**From:** Chair  
**Sent:** 14 May 2020 21:16  
**To:** Caroline Ford  
**Subject:** Albion Land Phase 2 Development proposals

**Albion Land Phase 2 development proposal**

Figure 8.3 – New Roundabout Junction

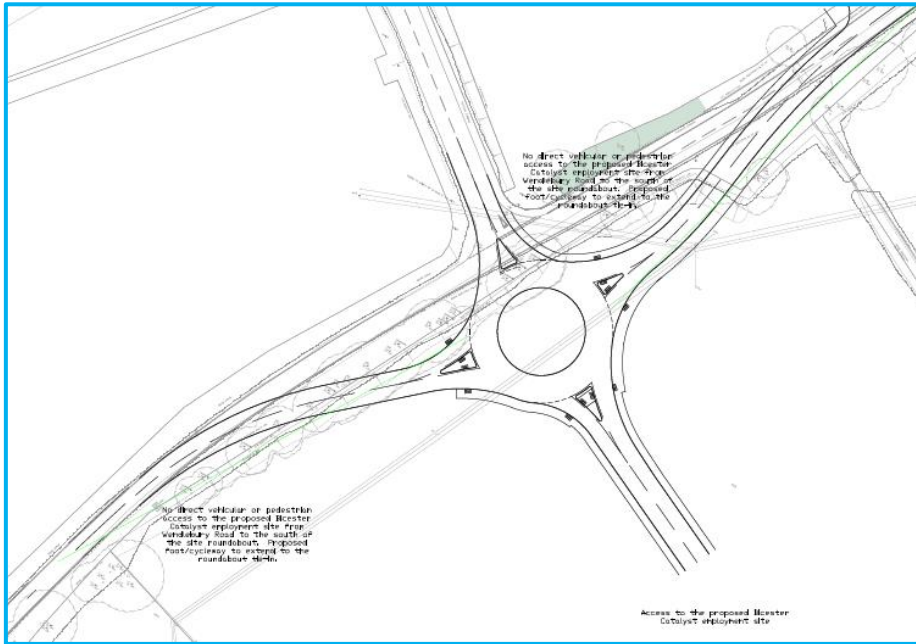
- (i) The Wendlebury Road roundabout is a source of concern both to Chesterton PC and Wendlebury PC and does not meet the policy tests initially envisaged. Why has this been changed? Please review this proposal.
